Portishead Branch Line (MetroWest Phase 1)

Planning Inspectorate Reference: TR040011

9.3.3 ExA.SoCG-EA.D7.V5 – Statement of Common Ground

Date: 14 April 2021

These notes are based on the use of experienced and competent contractors carrying out the work using an approved safe method of working.

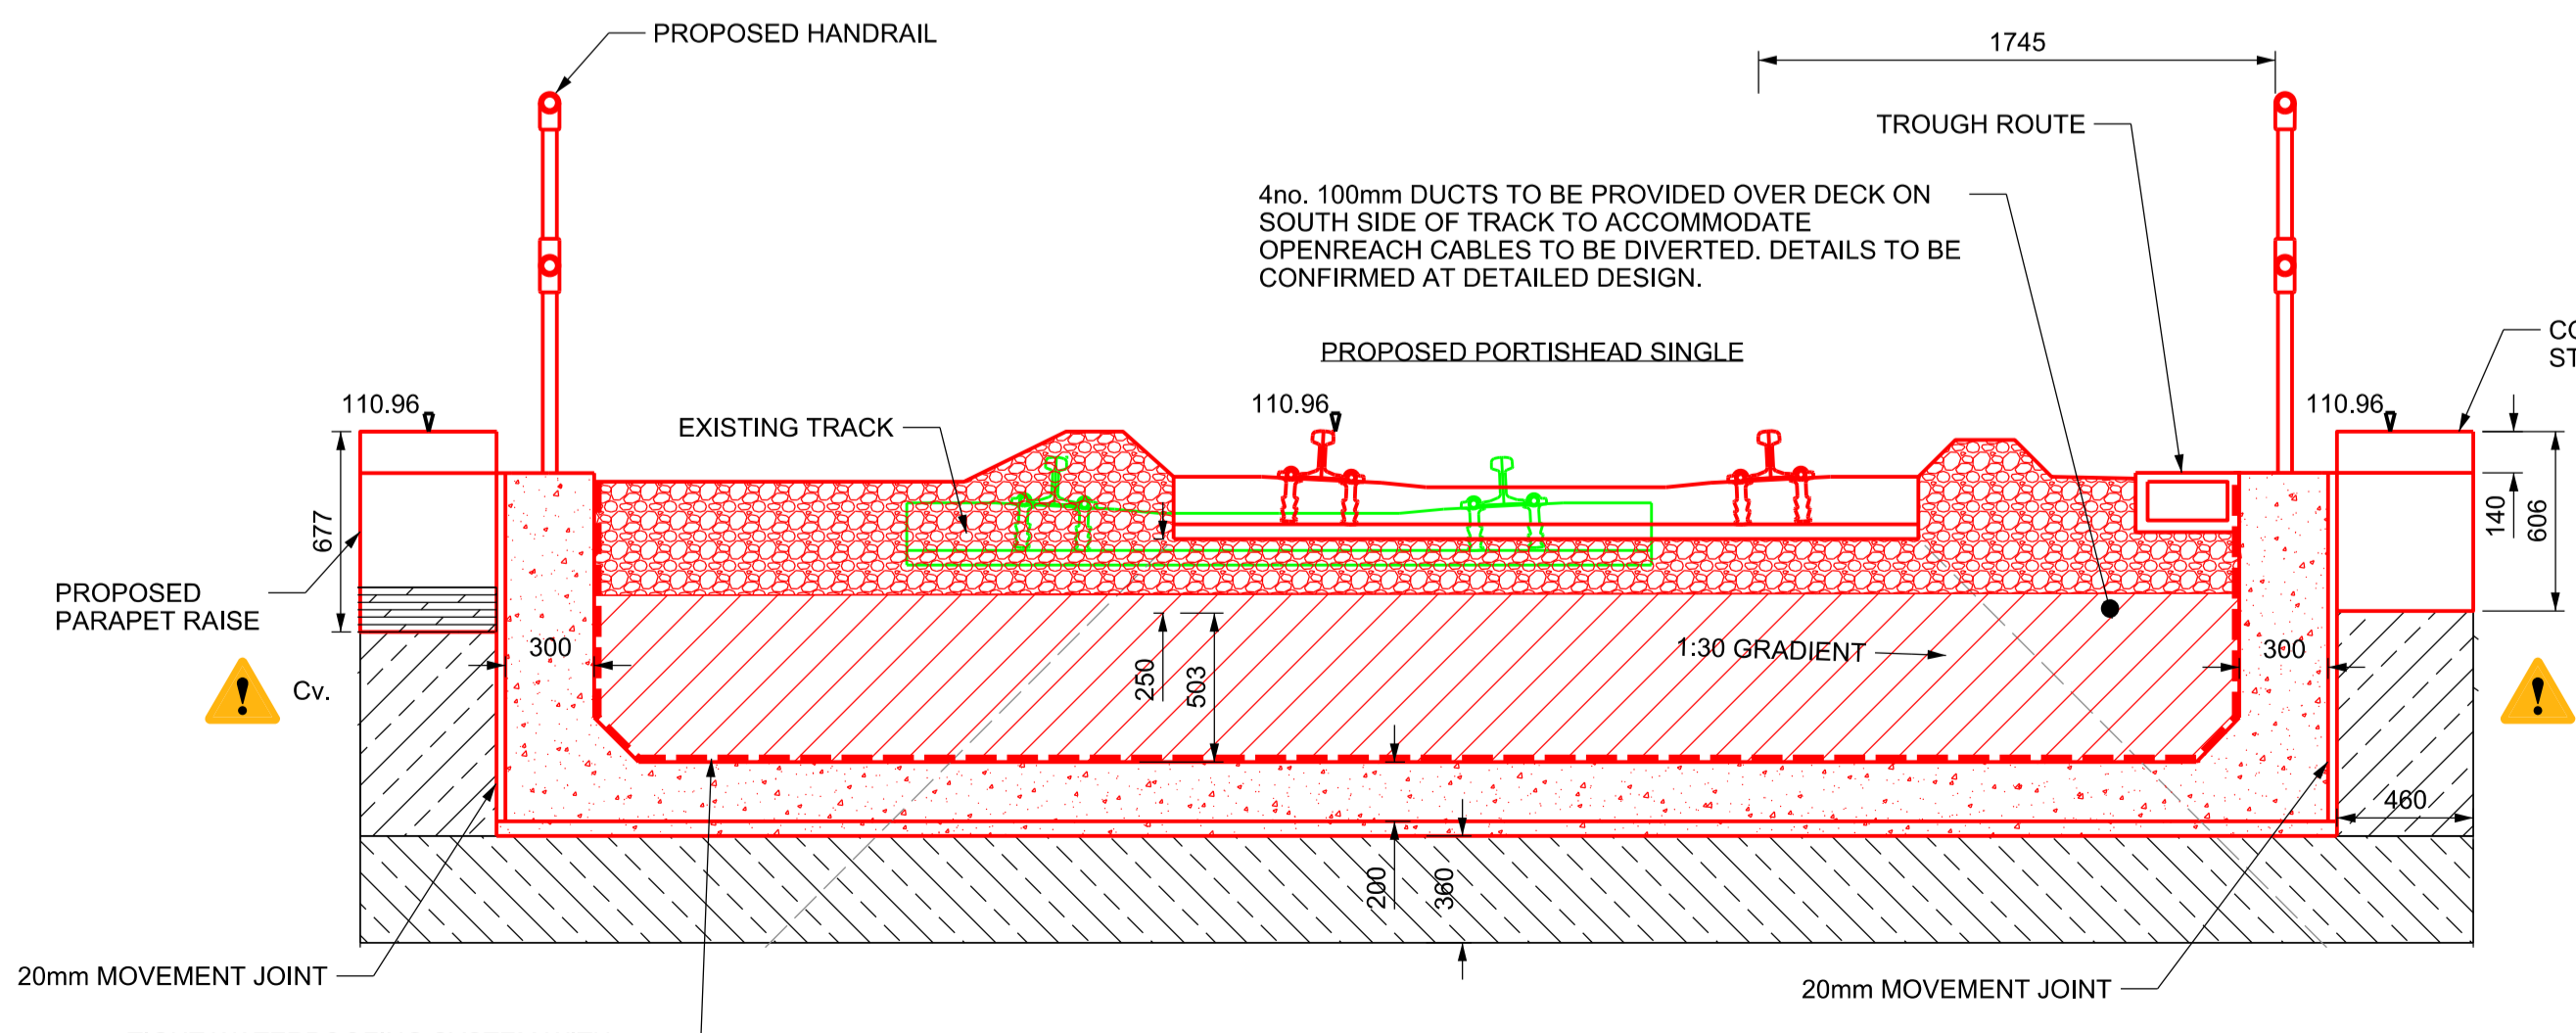
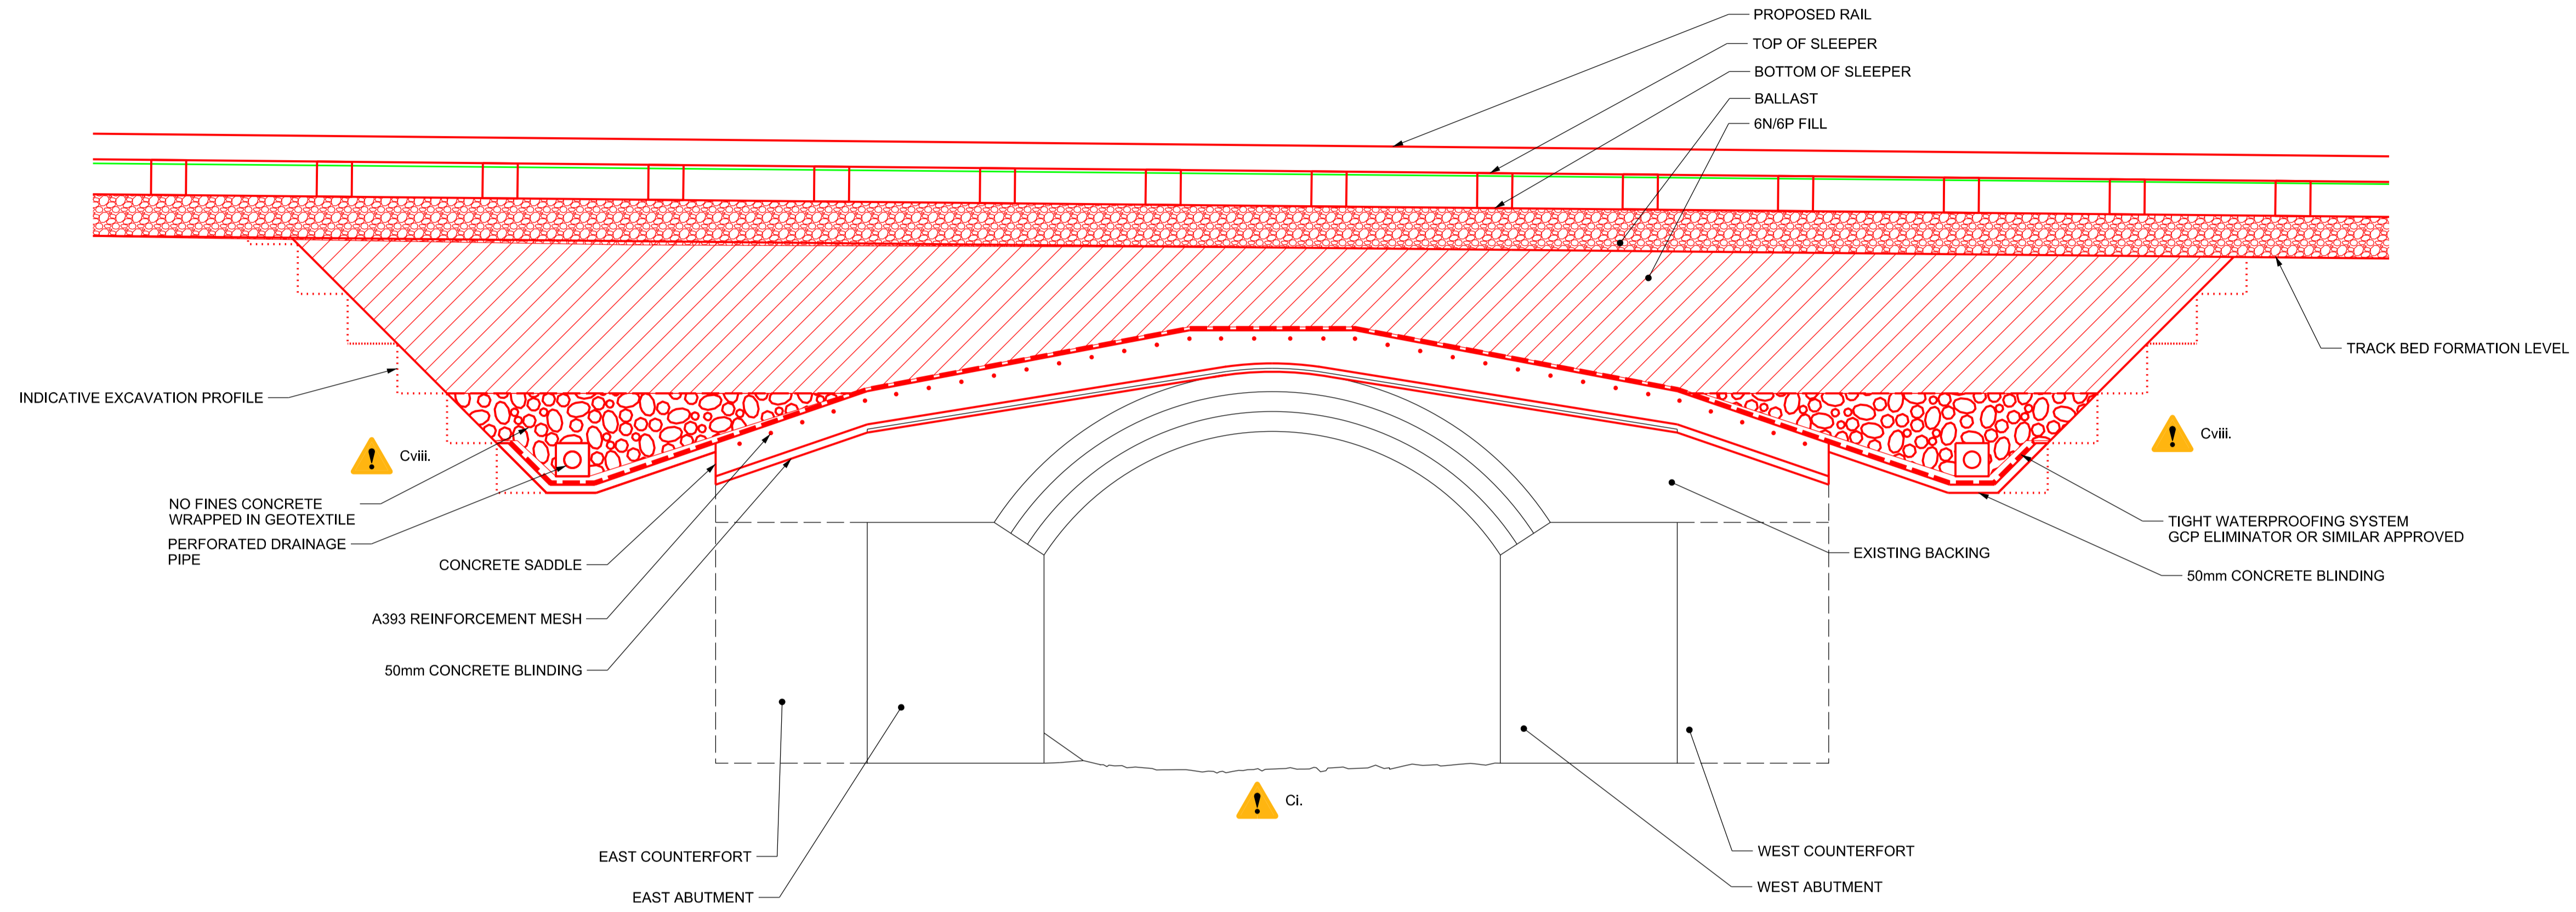
5.1.9	Easton in Gordano Stream	<p>The EA agrees that specific flood compensation is not required however, this relies on a flood relief channel in the form of a farm access track running under the railway line. As a result, appropriate provisions are required within the DCO.</p> <p>By email dated 30 March 2021 the EA state "Providing the means to secure the ground level and arch</p>	<p>There are no plans to block Cattle Creep access track and it will be maintained in its current form.</p> <p>The Applicant points out that sub section 2 of the new requirement 33 provides the comfort the EA requires.</p>	<p>Issue Resolved: The EA has accepted new requirement 33 for Cattle Creep access track within the dDCO with an amendment to retain the works thereafter. as follows:</p> <p>33.— (1) Work No. 1B must not commence before the undertaker has provided to the relevant planning authority and the Environment Agency a topographic survey setting out the existing ground levels at Cattle Creep bridge, Easton in Gordano.</p> <p>(2) Works to Cattle Creep Bridge must be carried out and retained thereafter in accordance with the principles set out in the Cattle Creep Proposed General Arrangement drawing and in particular the arch of the Cattle Creep Underbridge must not be altered and the ground level beneath the Cattle</p>

Ref	Topic	Environment Agency position	Applicant position	Status (Issue Resolved/Issue Outstanding)
		design is confirmed, the Agency can confirm the issue is agreed."		Creep Underbridge must not be raised without the prior consent in writing of the relevant planning authority following consultation with the Environment Agency and (if relevant) the lead local flood authority.
